City of Albuquerque Development Review Board
Submitted on: December 2, 2016

Project No. 1005354
16EPC-40059 - Amend Site Development Plan for Building Permit
16EPC-40060 - Amend Site Development Plan for Subdivision

**Final Sign-off for EPC-approved
Amended Site Development Plan for Subdivision and Building Permit
Sawmill Village Redevelopment - Phase 2
Tract 2-D-1 of ARBOLERA DE VIDA, Unit 2B
(To subdivide into Tract 2-D-1A and 2-D-1B)**

**N** Landscape Plan  
Sawmill Village

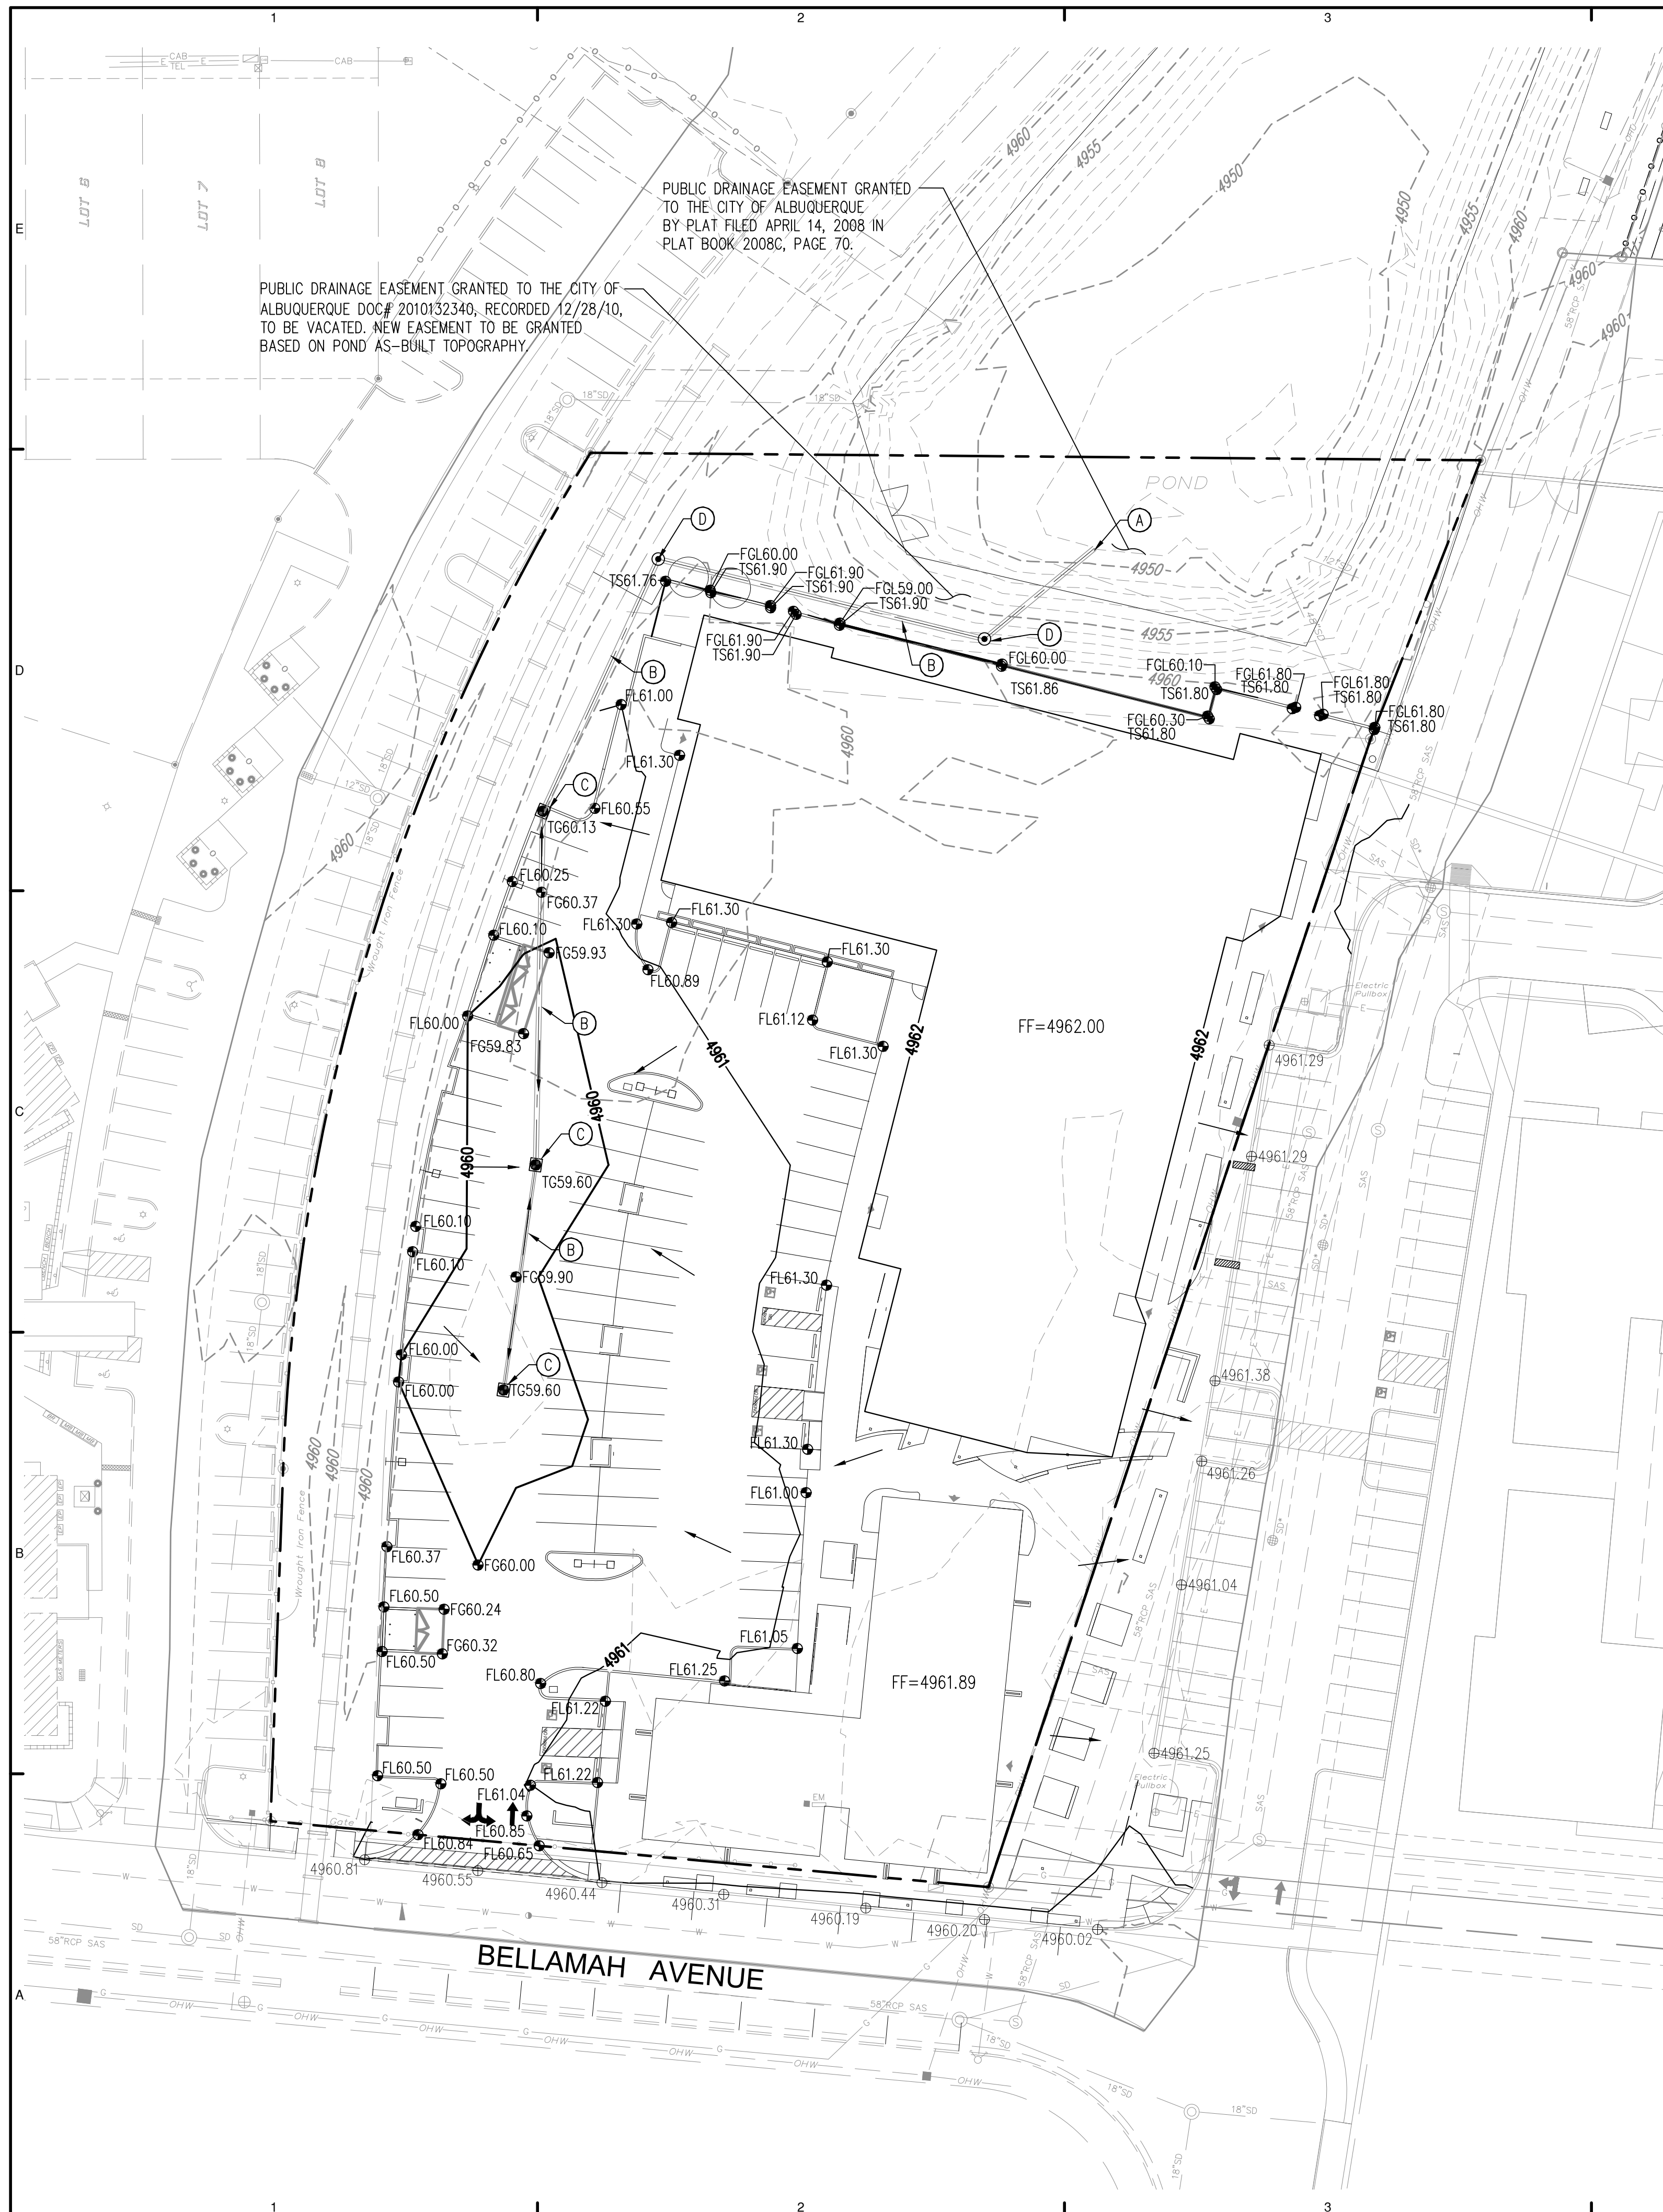
- A. *One of the two additional trees (the northernmost one) approved with the 2011 landscaping plan, along the western boundary of Phase II, shall be included with the current landscaping plan.*

- B. *The trees along Bellamah Ave. shall be of a tall, canopy-forming variety (such as Red Oak approved in 2011 or a canopy-forming tree on the current landscape legend).*

Refer to plan on Sheet SDP 2.0 for locations of all trees along the western boundary that comply with 2011 landscaping plan.

Refer to plan on Sheet SDP 2.0 for revised tree species specified along Bellamah Ave.

**SDP-5.0 V3**

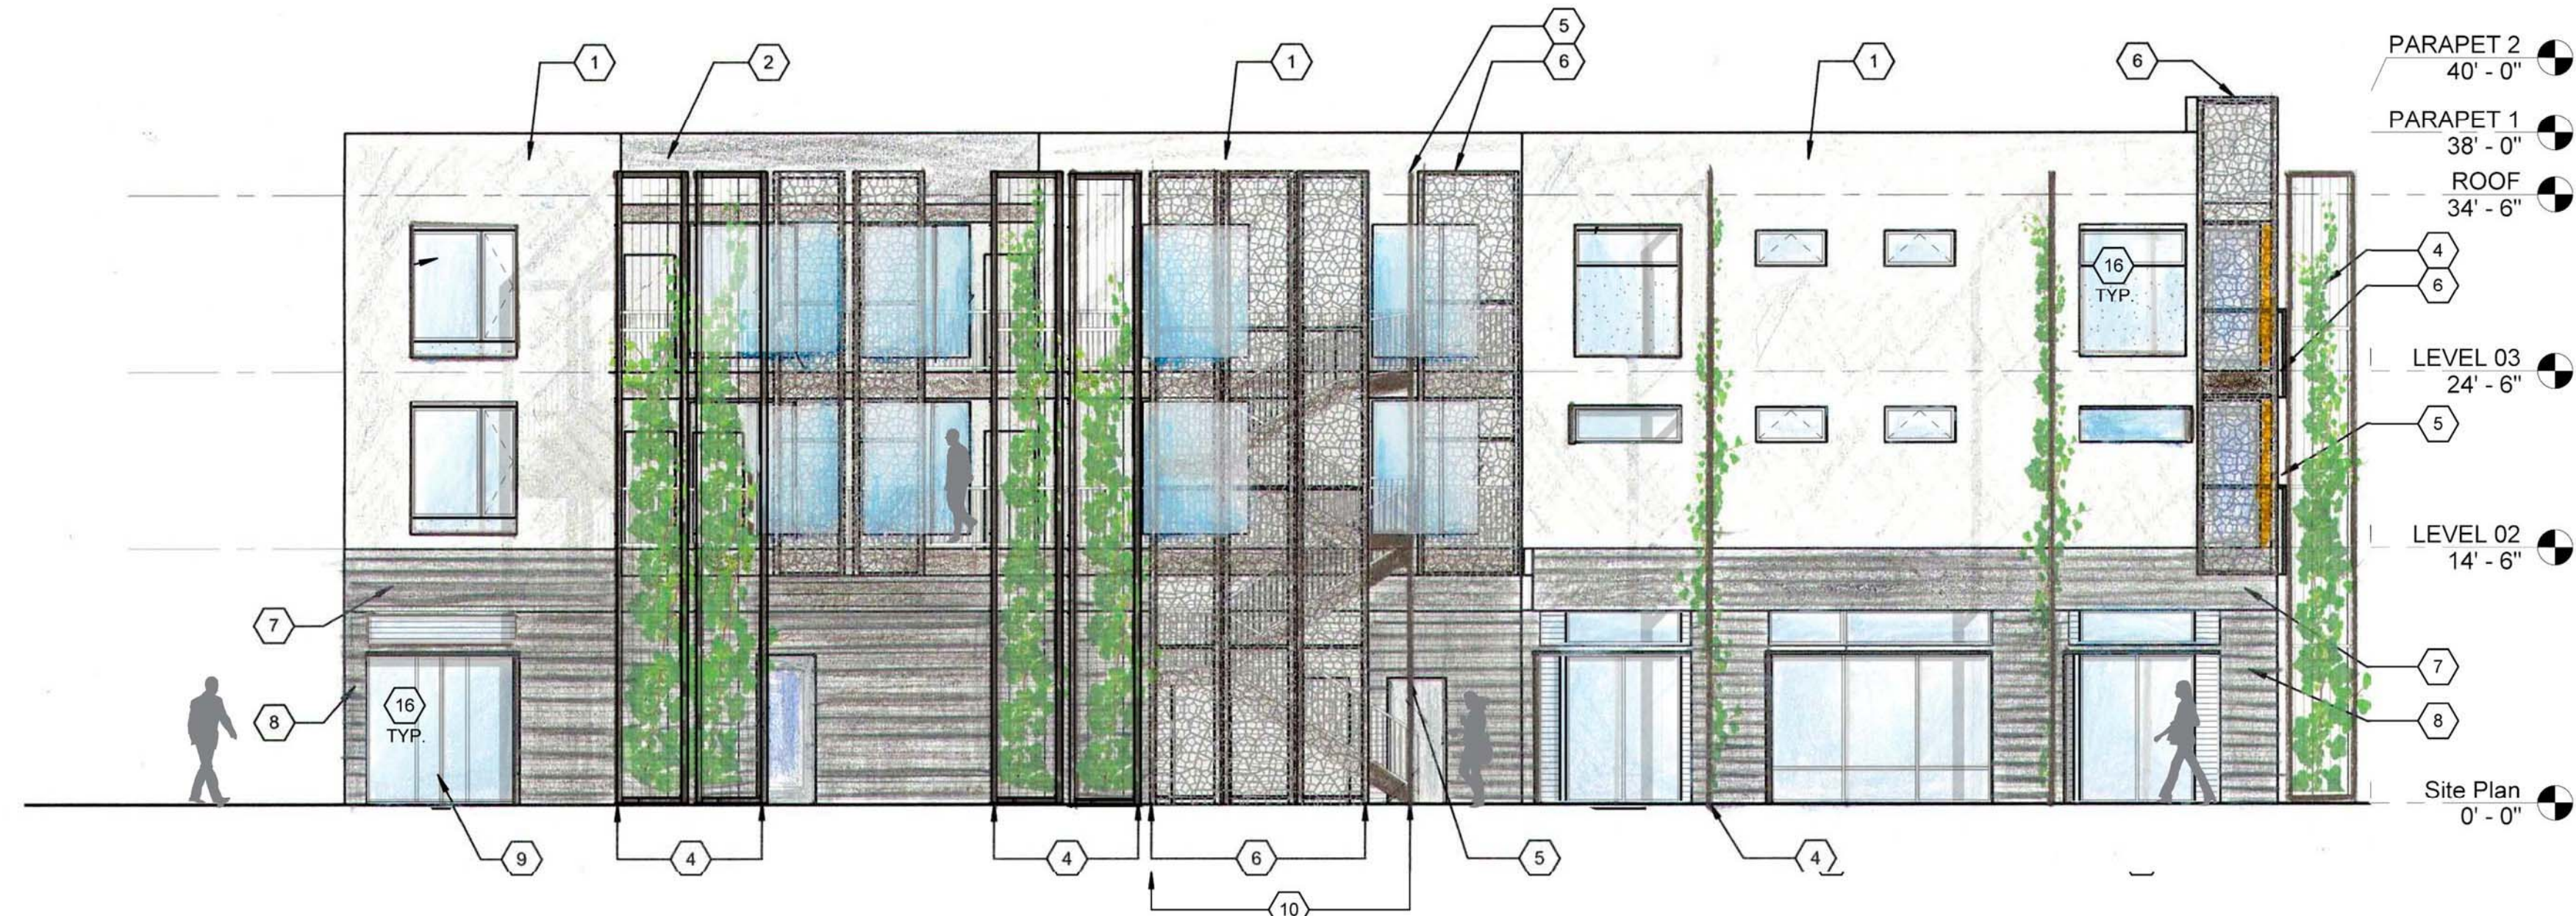
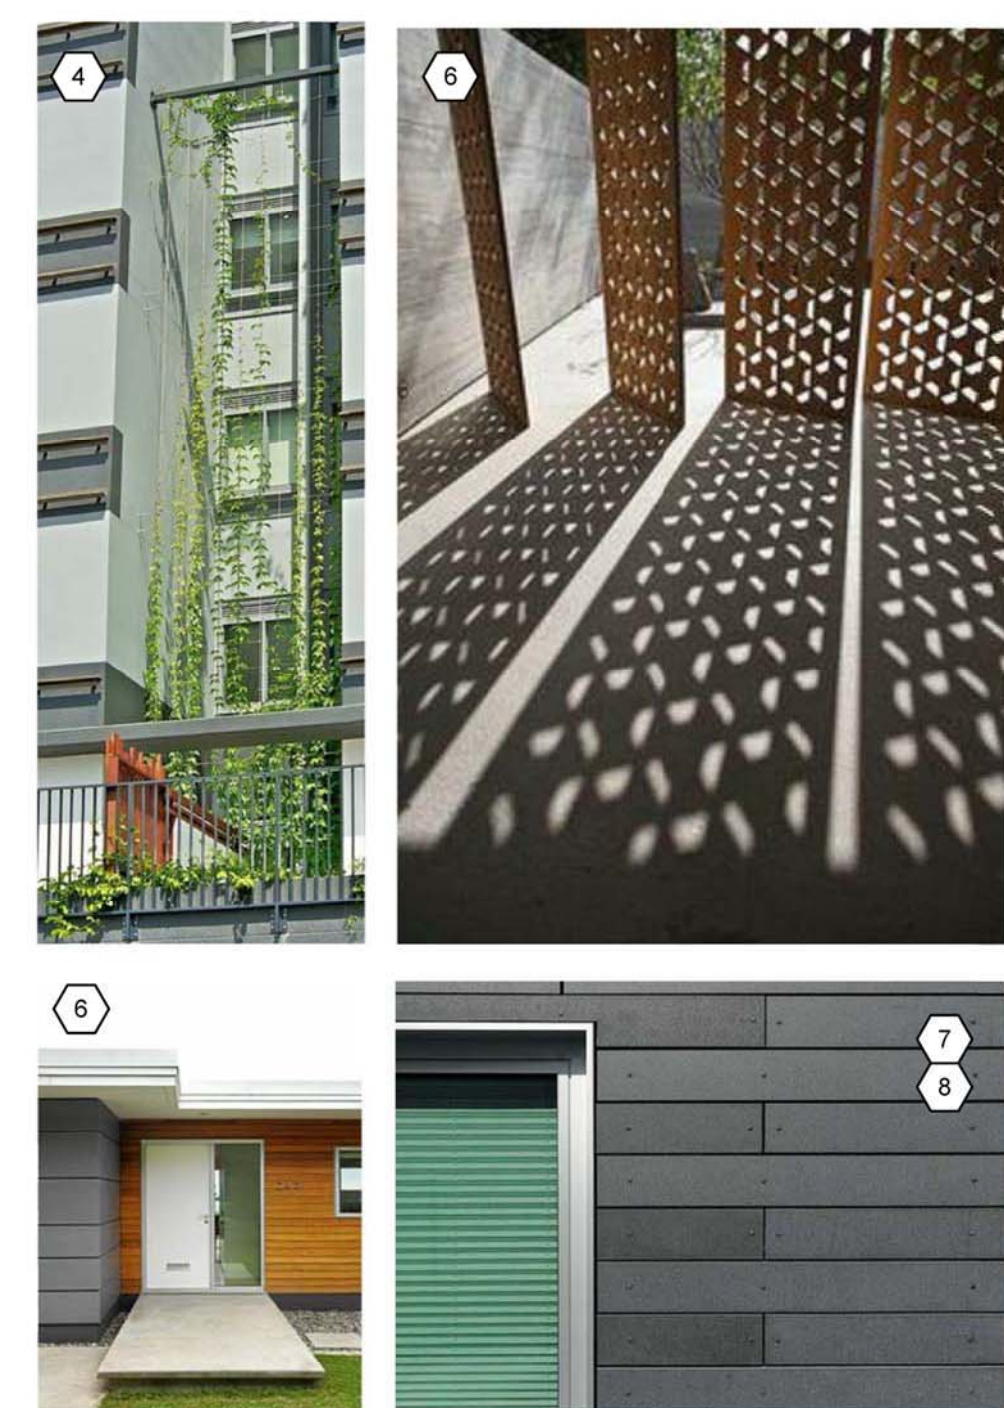
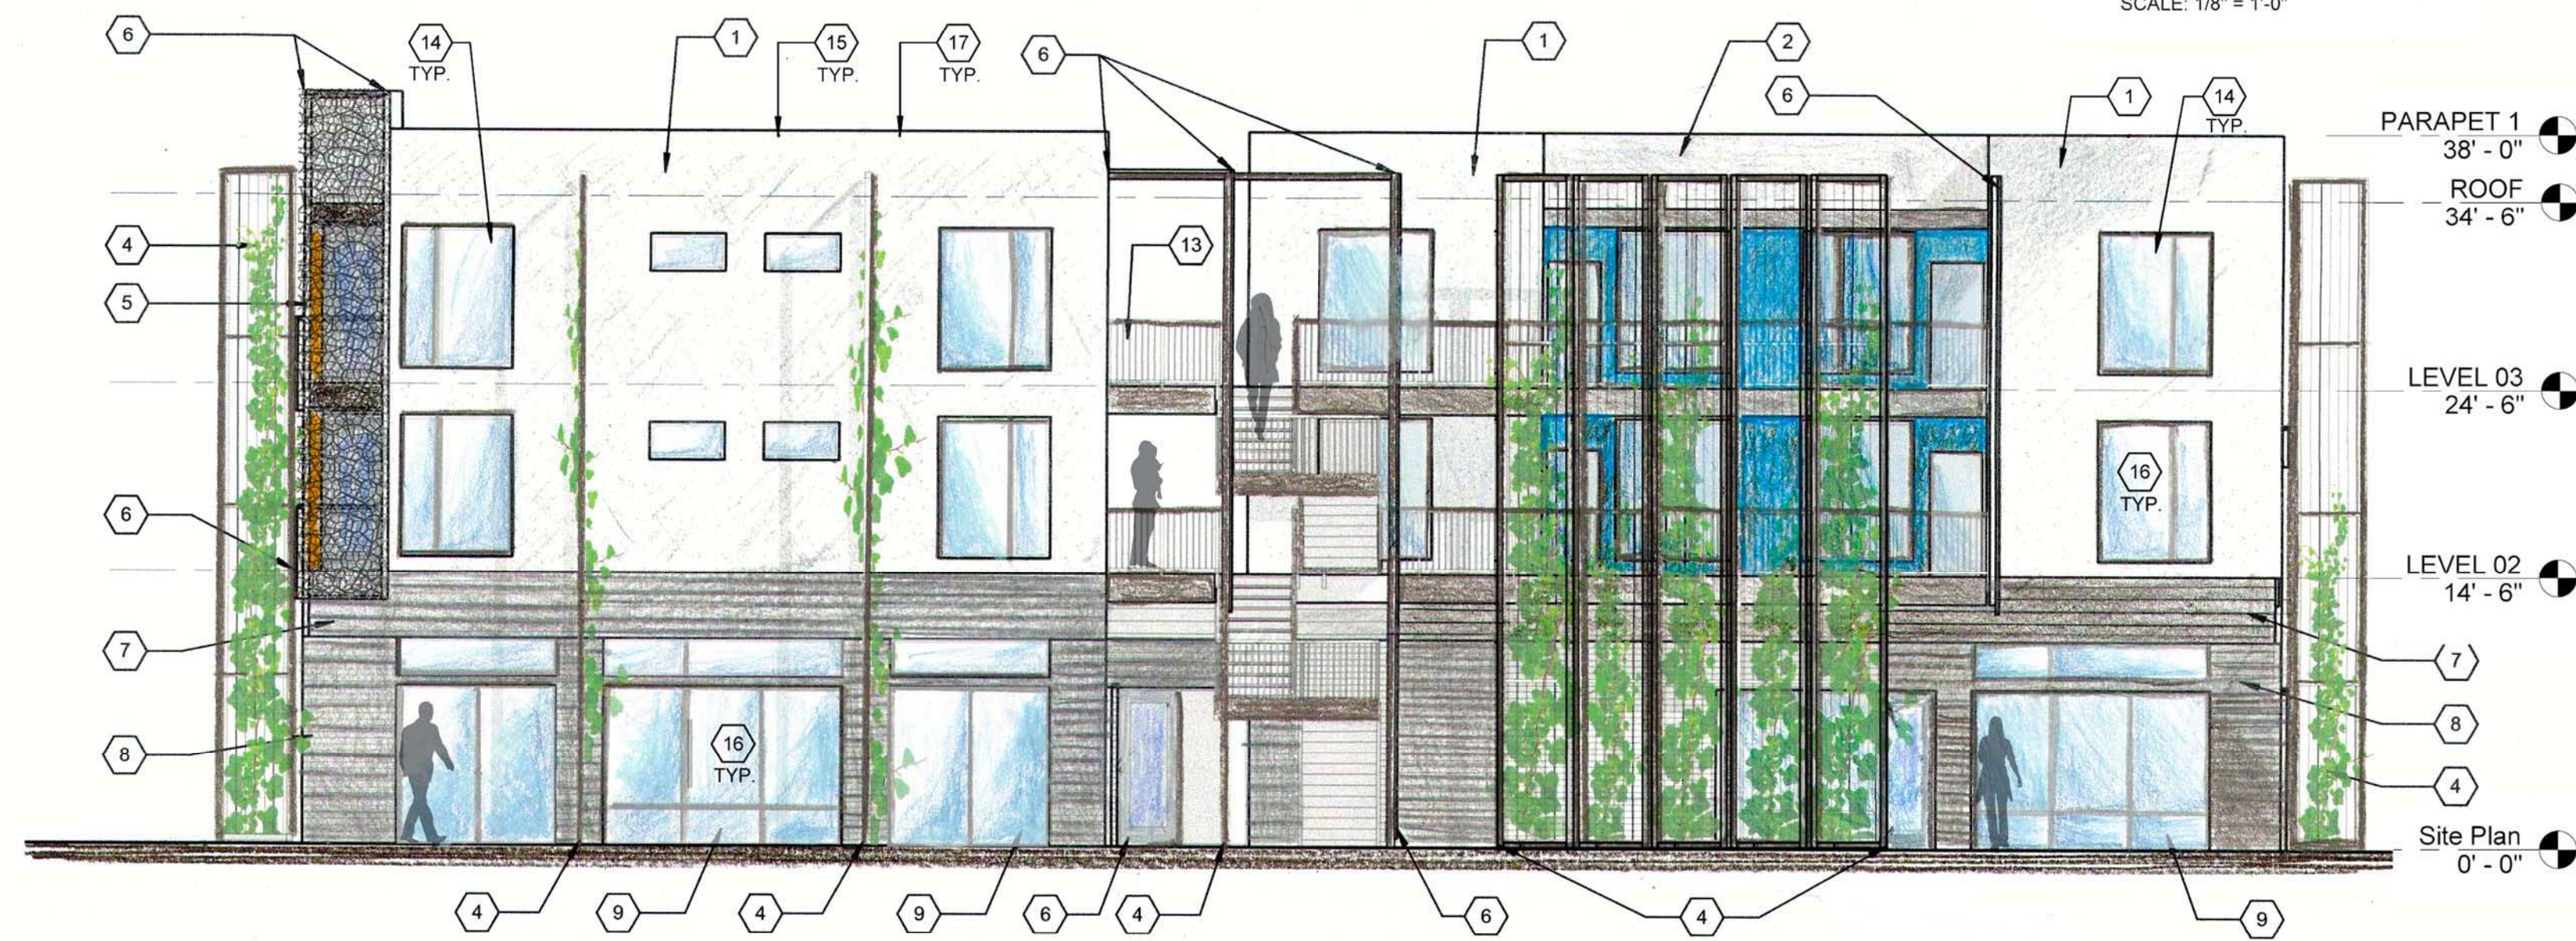
- A. *A note shall be added to the elevations to indicate that mechanical and electrical equipment shall be screened from public view (Regulation 4.d).*

- B. *A note shall be added to the elevations to indicate that reflective glass is prohibited (Regulation 4.f).*

A. *The accent material of the buildings will be specified as stained cement panels to be consistent with the materials used in Sawmill Village (Exterior Wall Materials and Colors section).*

B. *A note needs to be added to the elevations to indicate that roofs will be a low heat absorbing single-ply material in a light color (Roof Materials and Colors section).*

Refer to Note 15 on Sheets SDP 5.0 and SDP 5.1 as well as Note 16 on Sheets SDP 5.2 and SDP 5.3 regarding roof-mounted mechanical and electrical equipment.

Refer to Note 16 on Sheets SDP 5.0 and SDP 5.1 as well as Note 17 on Sheets SDP 5.2 and SDP 5.3 regarding reflective glass.

Refer to Note 7 on Sheets SDP 5.0 and SDP 5.1 for specified stained cement panel material locations.

Refer to Note 17 on Sheets SDP 5.0 and SDP 5.1 and Note 18 on Sheets SDP 5.2 and SDP 5.3 regarding low-heat absorbing materials.
